DEVELOPMENT REVIEW BOARD
SUPPLEMENTAL SUBMITTAL

PROJECT NO. PR-2020-004708

Application No. SI-2020-001411

Explore Academy

SHEET NO.
SDP1.1
OF

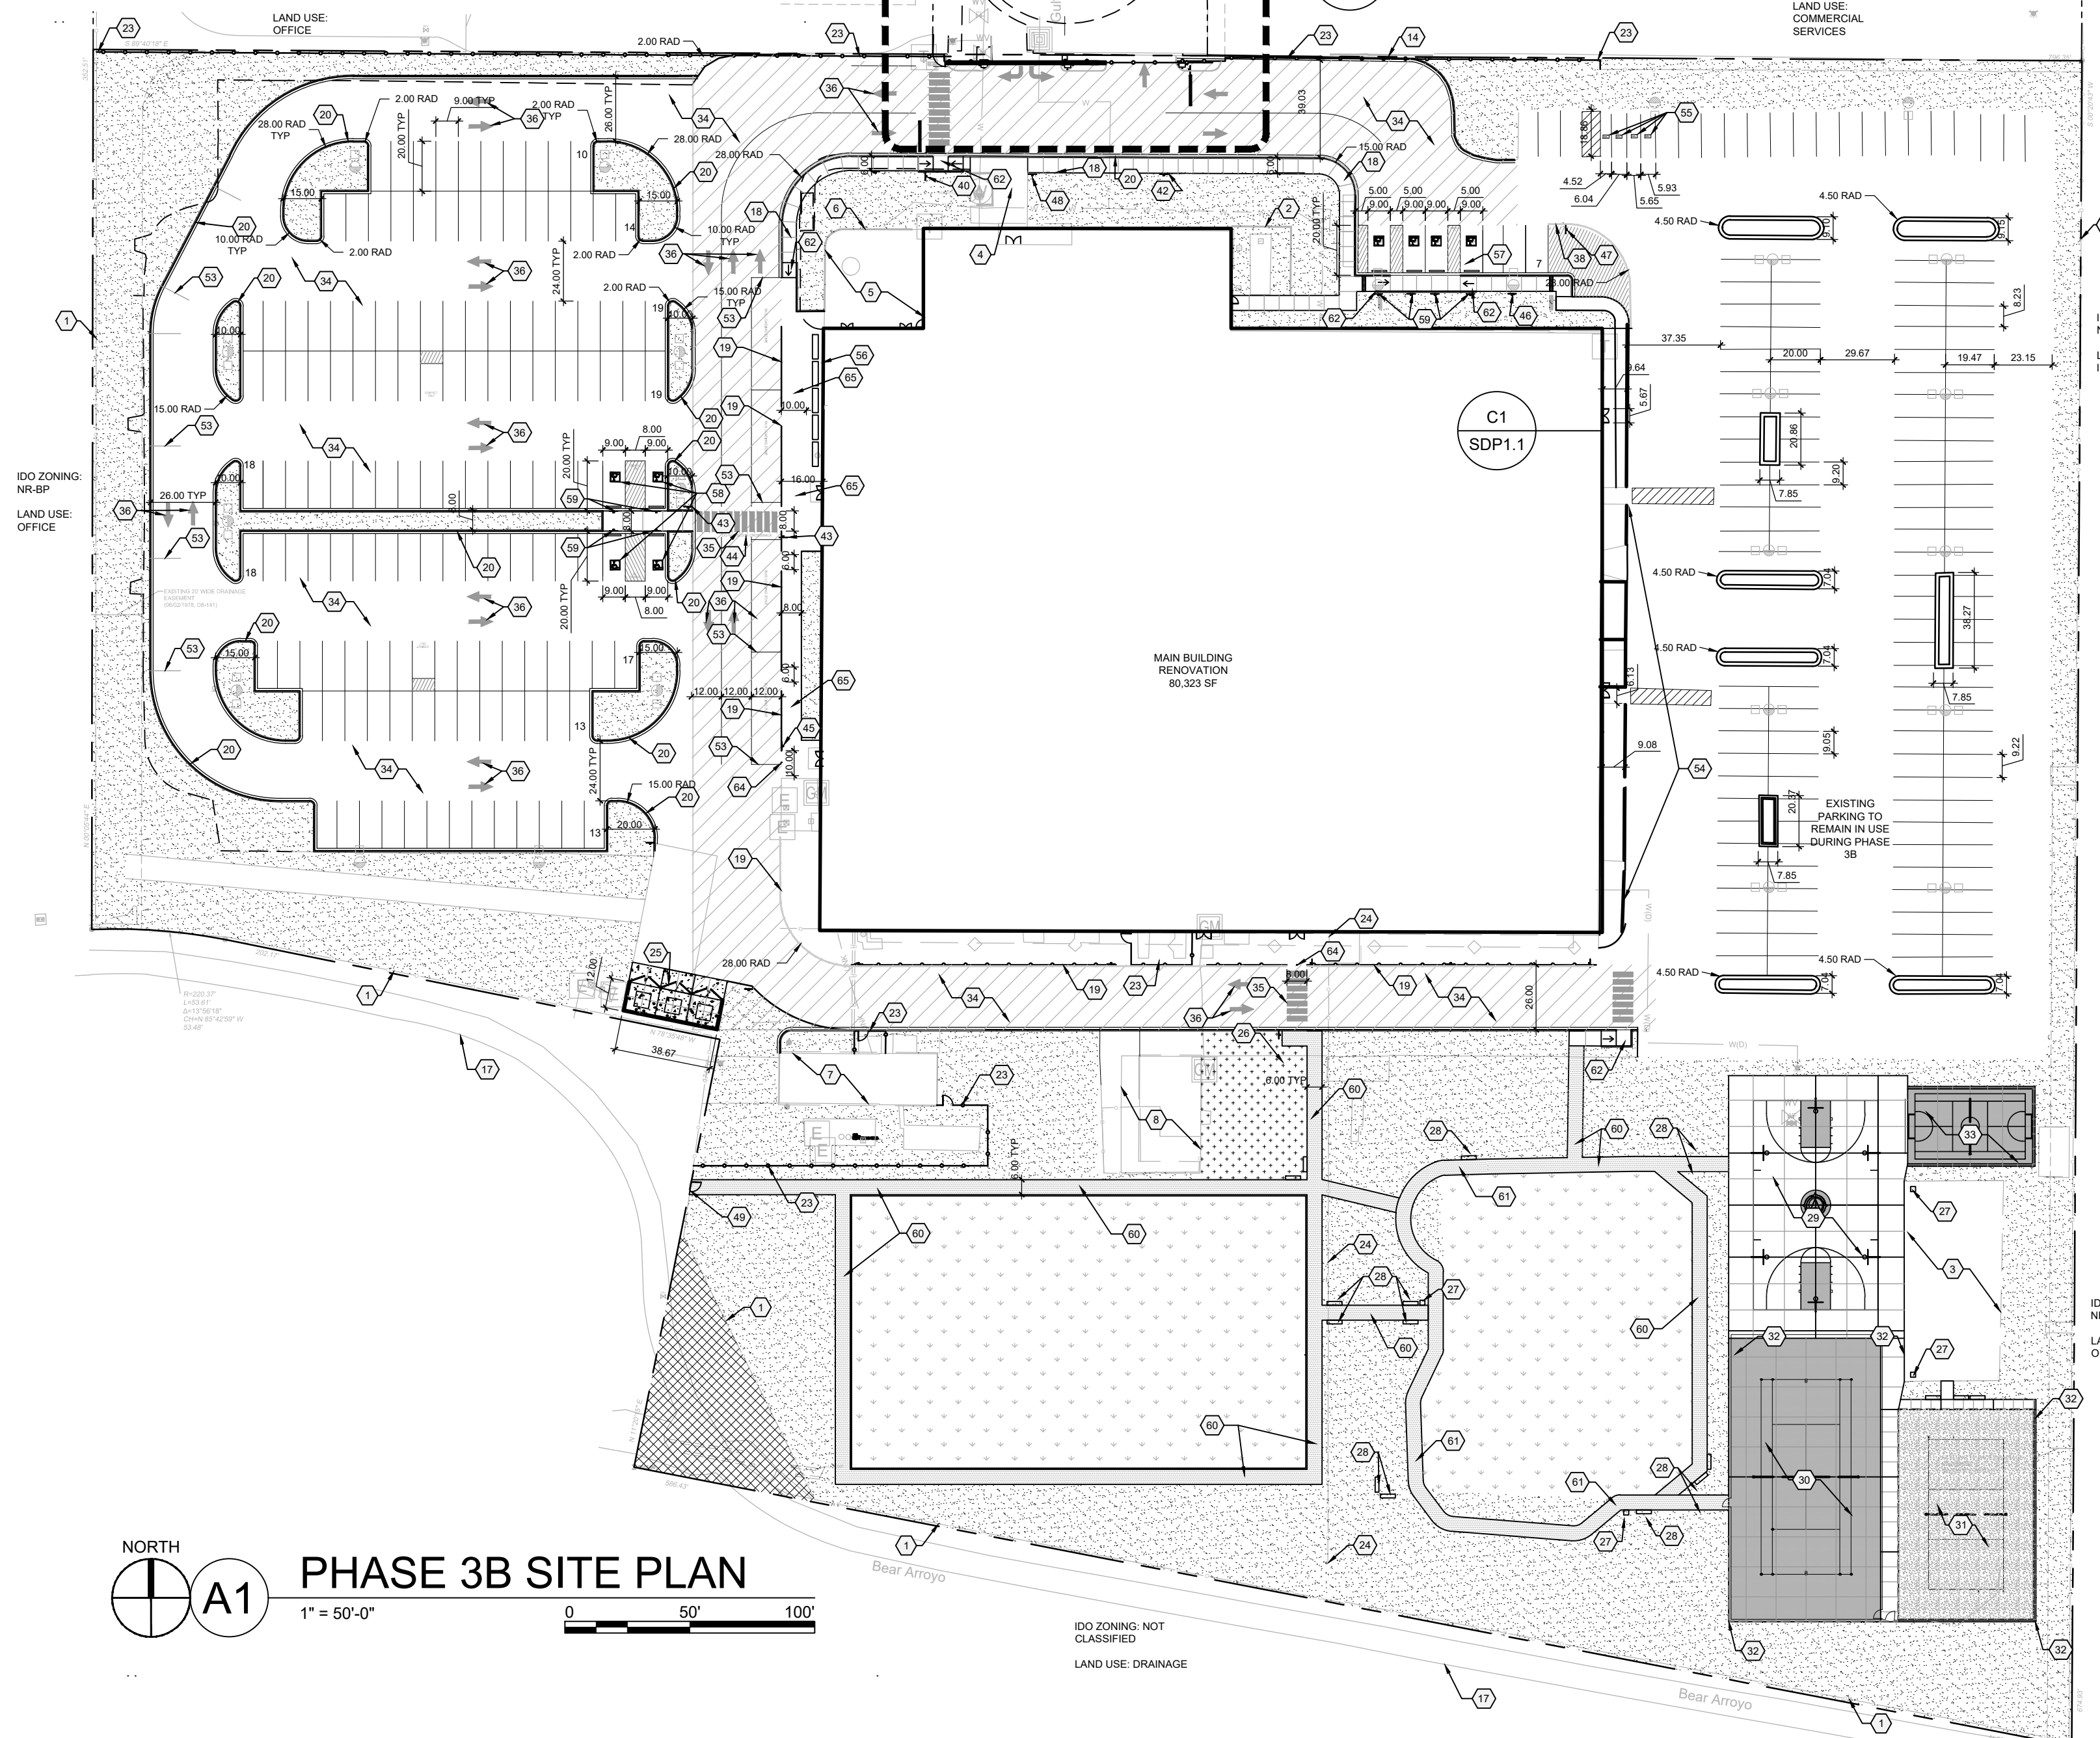
4. List curb radii within parking lot on east side of school, even if much of this is existing.. Also along the east side, show typical dimensions of parking spaces, doorway entrances, and existing pedestrian path widths.
See revised SDP1.1.

5. Clarify if sidewalk is flush with curb along west side of school. If not, curb ramps need to be identified at this location.
See revised SDP1.1.
6. Dimension landscape medians within parking lot.
See revised SDP1.1.

12. The handicapped spot immediately east of the egress to Gulton Court does not have a safe place to back out. Parking may need to be shifted if there is no place to place a keyway.
See revised SDP1.1. One parking space was deleted and striping was added to provide space for backing out of the accessible parking space in question.

13. Label all pavement arrows on-site.
See revised SDP1.1.
14. Where is the motorcycle parking?
See revised SDP1.1.
15. Call out handicapped signage and motorcycle parking with keyed notes on the plan.
See revised SDP1.1.

C4 PH4 CIRCULATION DIAGRAM
NTS

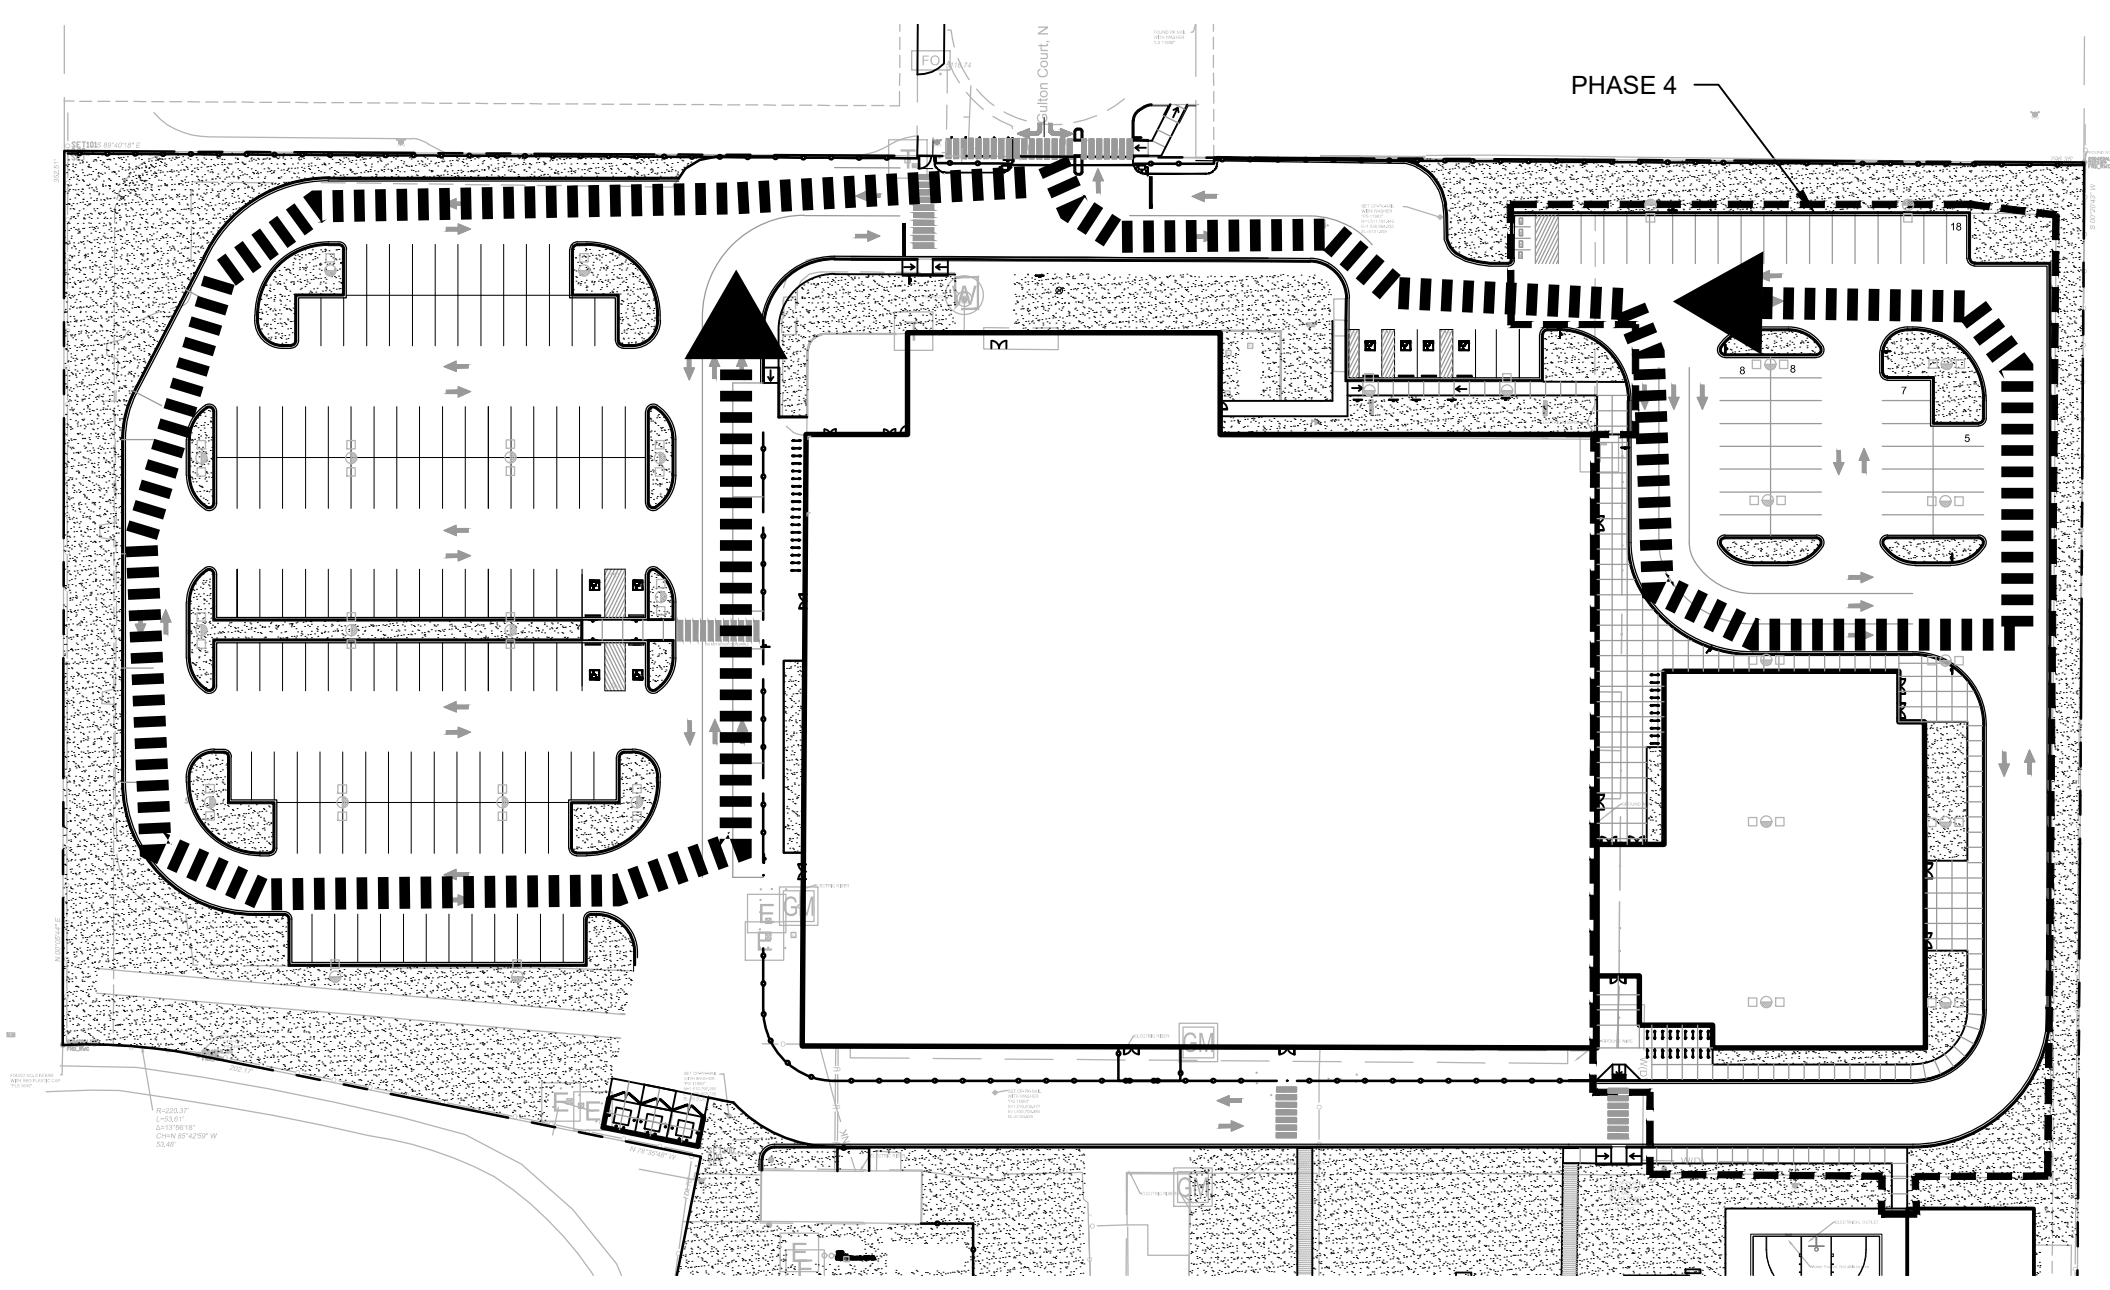
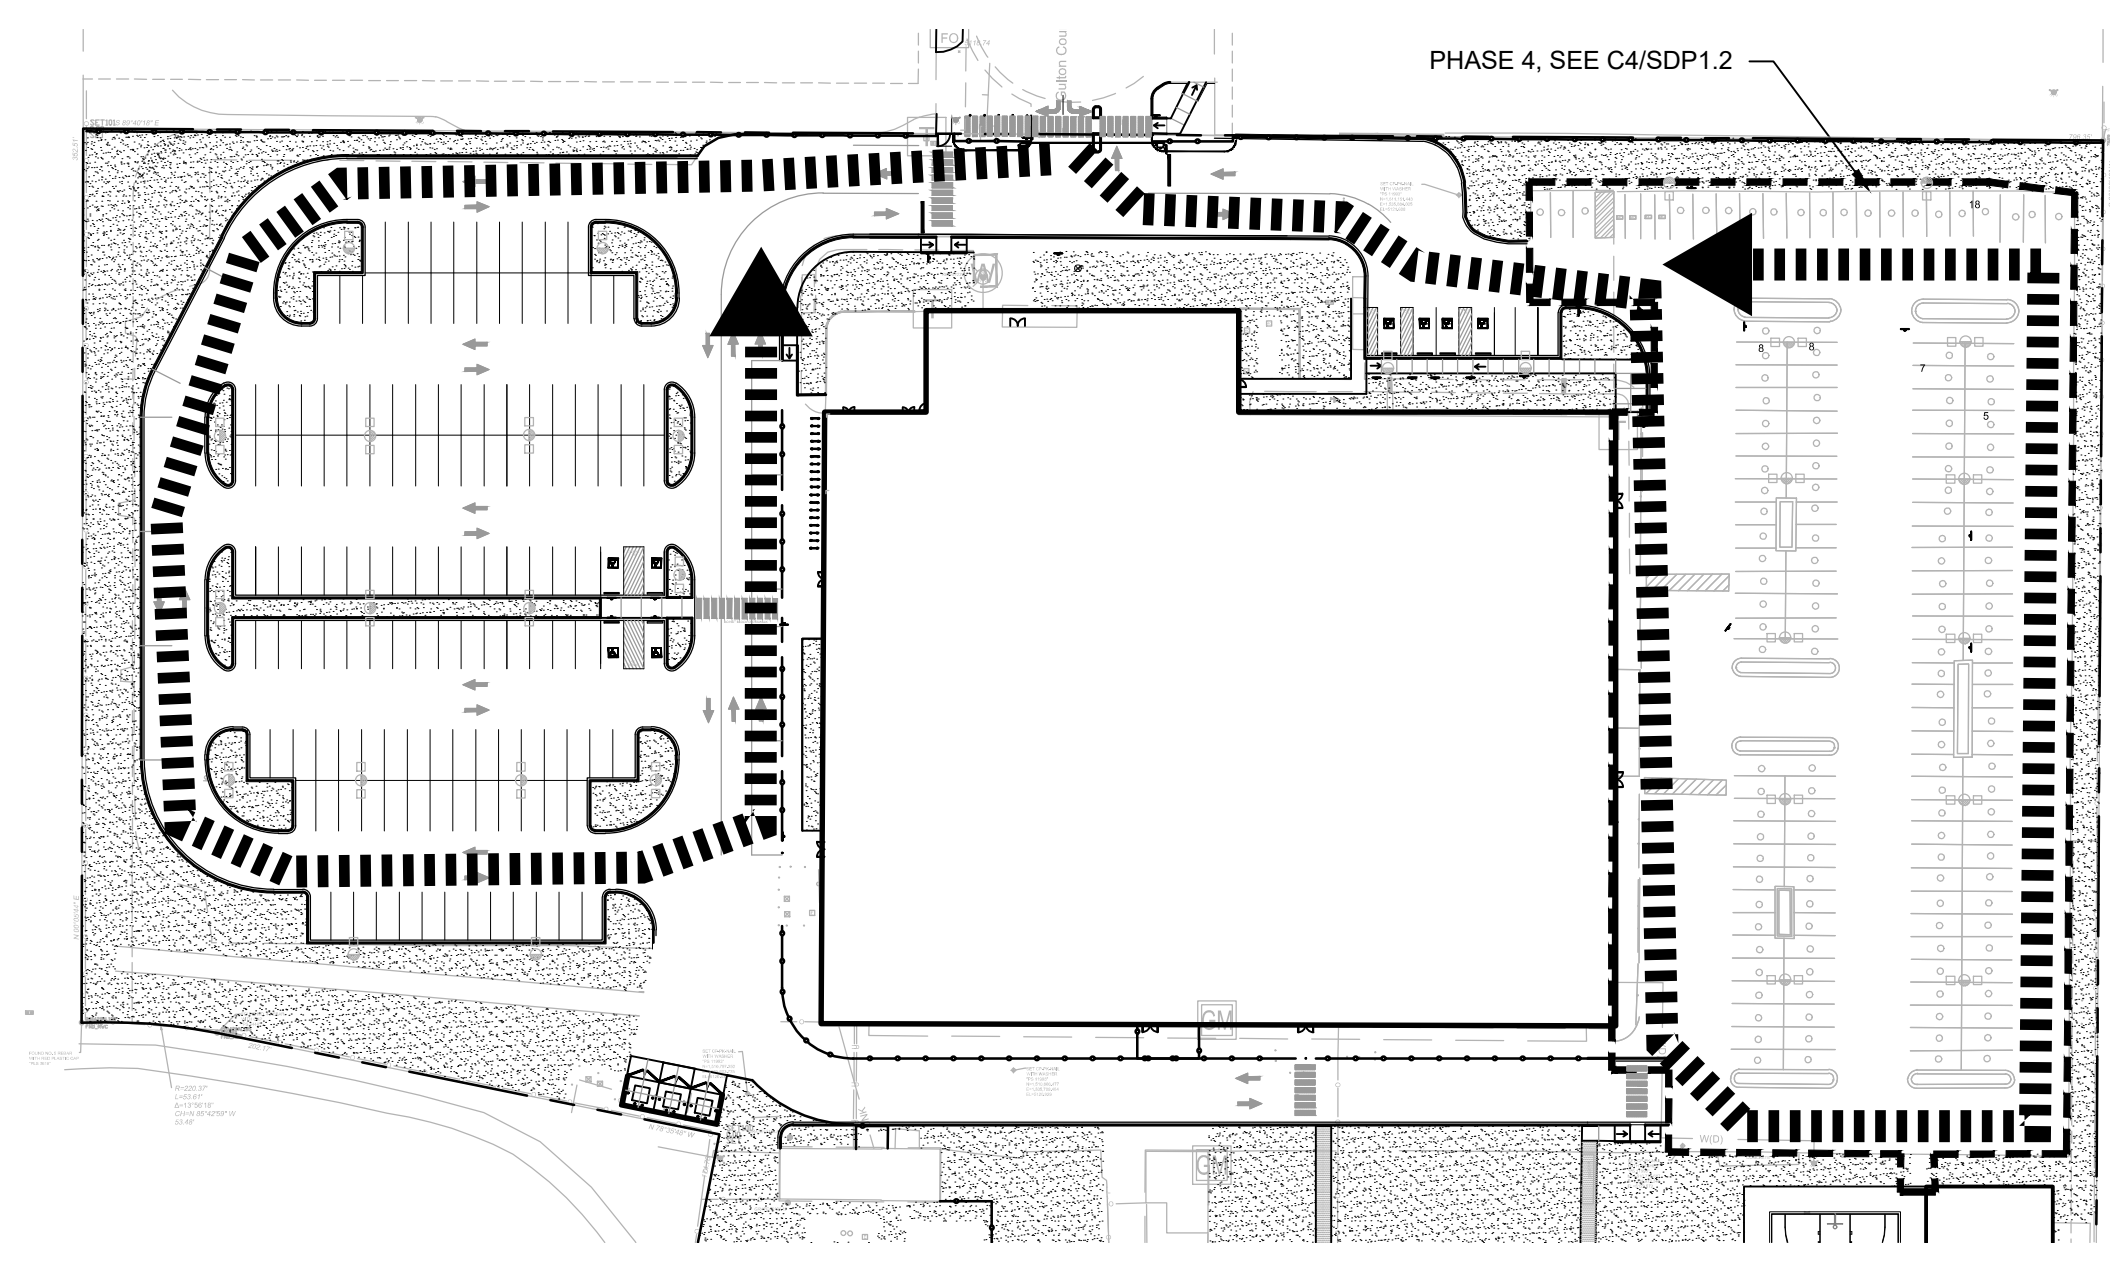
10. For one-way aisles, ingress and egress, include "Do Not Enter", "One-way" signs, and directional pavement arrows as necessary. Also clarify when gates are open.
See revised SDP1.1 and SDP1.2.

C3 BICYCLE RACK
NTS

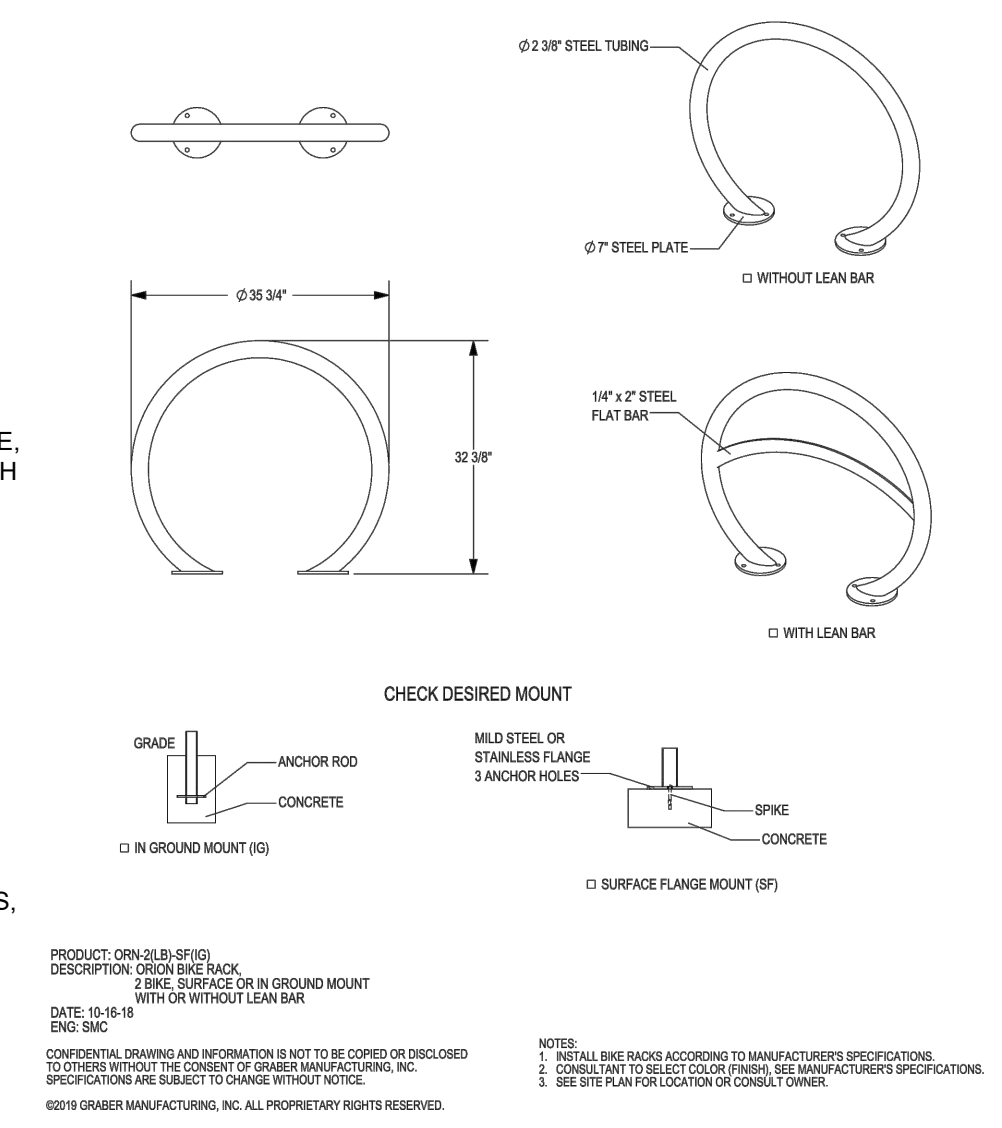
7. Bike Rack detail shall meet IDO standards. Bike rack detail appeared to be missing on detail sheet.
See revised SDP1.2.
8. Within Gulton Court, show how pedestrian paths tie in with existing sidewalk. Dimension sidewalk and crosswalks within Gulton Court and to the school site. Label existing sidewalk widths and drivepads. Also show property lines at this location.
See new sheet SDP1.3.
